RE: Tree Inventory 9740 SE 35th Pl., Mercer Island, WA.

This revised report is provided to address the inventory I conducted back in 2016 on the property at the address of 9740 SE 35th Pl. in Mercer Island. This report presents my prior findings and additional information as requested by the City of Mercer Island in the recent comment letter. At the time of the original report preparation, no development measures affecting tree retention had been specified, therefore no protection or replacement guidelines were provided. Since then, the project proposal has specified tree removal and retention for the development. In addition, the Mercer Island tree regulations have been revised requiring additional information not required at the time of the original report. This report provides information as required in the Mercer Island tree code found in MICC 19.10.

TREE INVENTORY PLAN ON THE ROCK 98040 9740 SE 35TH PL. MERCER ISLAND

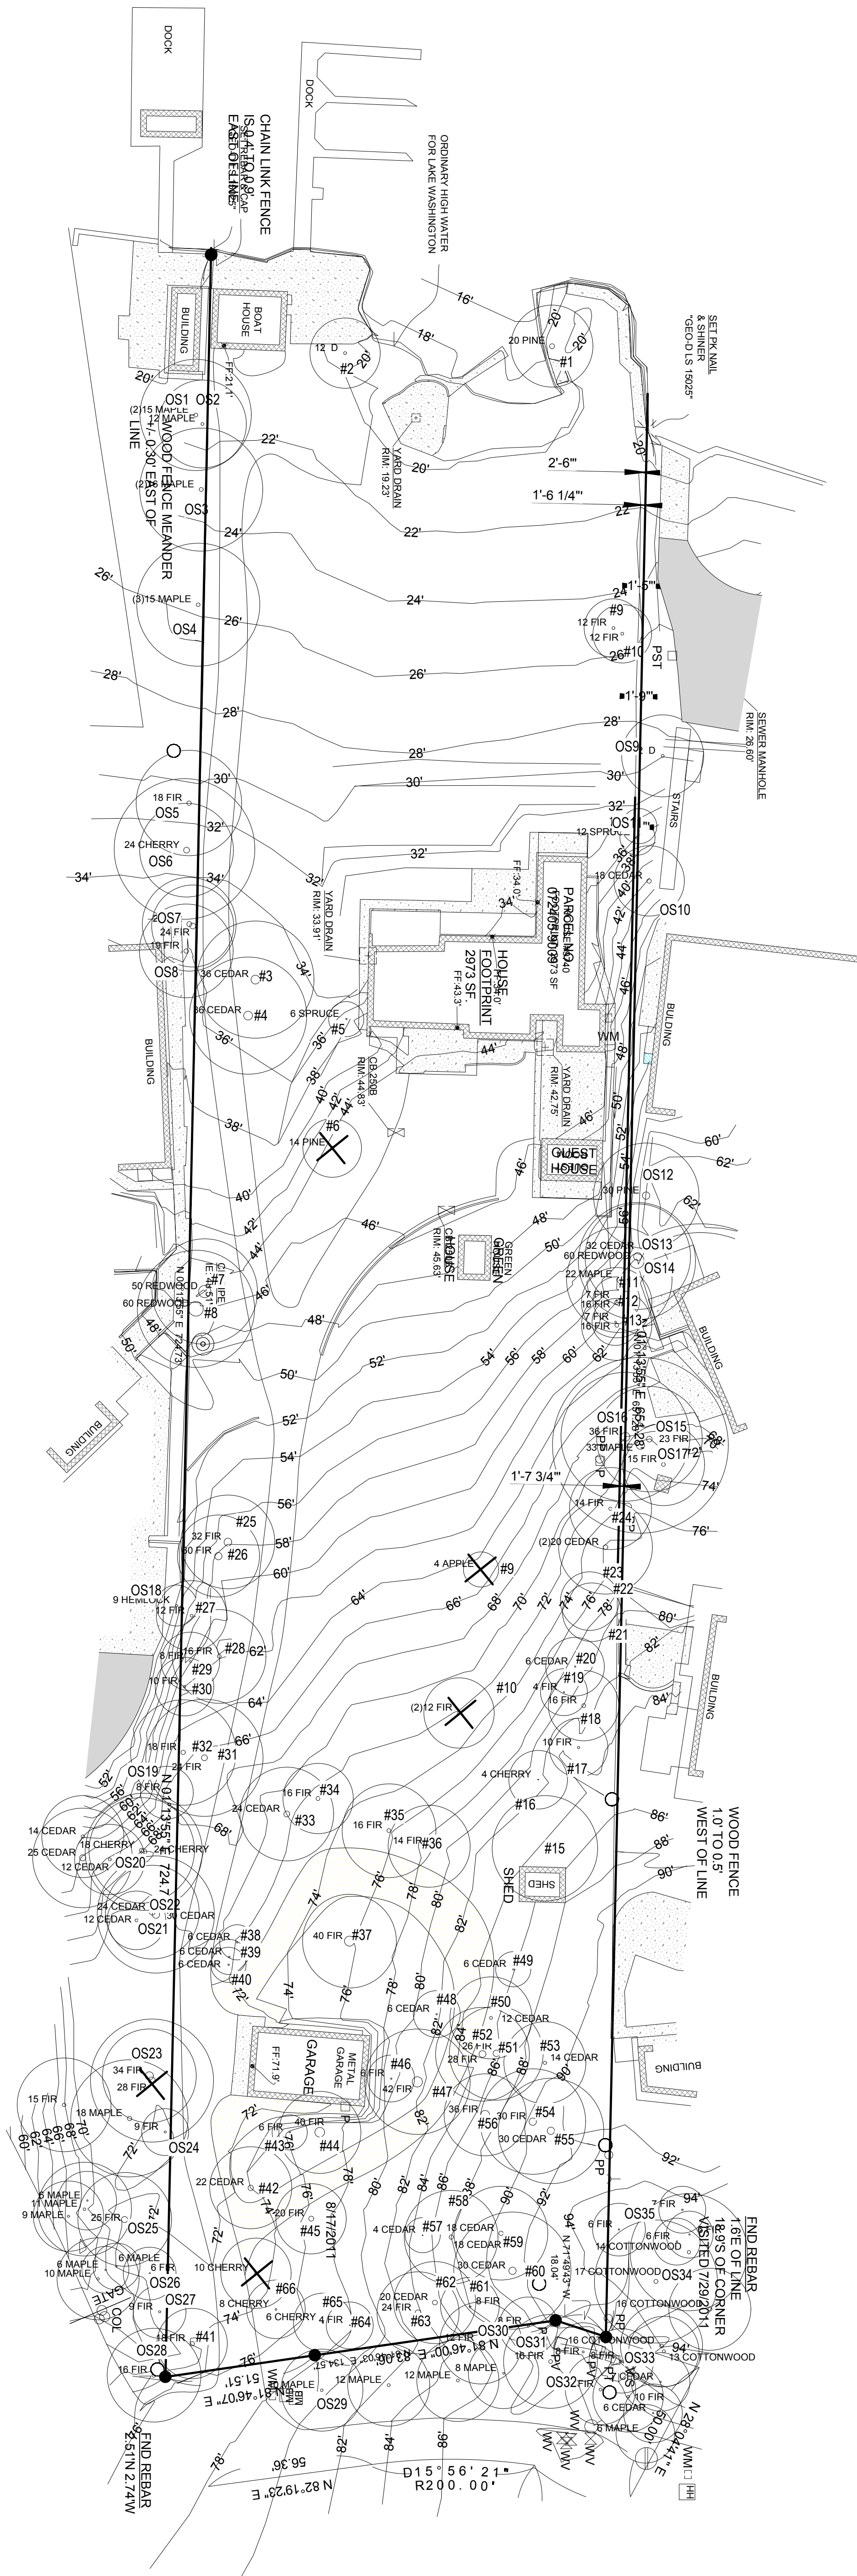
- Arborist report incomplete. No species or size or exceptional grove information in Arborist report. Provide a complete description of each

- tree's diameter, species, critical root zone, limits of allowable disturbance, health, condition and viability.
- A description of the method(s) used to determine the limits of allowable disturbance (i.e., critical root zone, root plate diameter, or a case by case basis description for individual trees).
 - The suggested location and species of replacement trees to be used when required. The report shall include planting and maintenance specifications to ensure long term survival.

I recently conducted an inventory of the trees on the property and those just off-site with driplines that extend onto the property. Using the survey, I identified each tree on the site and labeled them with numbered metal tags. These numbers shown on the Tree Inventory Plan. I also identified the trees just off-site with driplines that extend onto the project site.

The survey shows 69 trees on the property, however, 4 of these have been removed for a total of 65 trees on the property. The comments request information on when these trees were removed. These trees were numbered 6, 67, 68 and 69. Information on these trees is provided in this report. It is not known when the trees were removed, nor whether they have been replaced. One of the trees shown located just off-site to the west has also been removed. There are 35 trees just off-site with driplines that extend onto the project site.

I gathered information on each tree including species, dbh and performed visual assessments of each tree from up close to inspect the trunk and root collar and for the larger trees also from afar to observe conditions of the crown. The crown spread measurements were gathered during the site survey and are provided in the inventory plan. All of the information specific to each tree is provided on the accompanying Tree Evaluation Data spreadsheet.
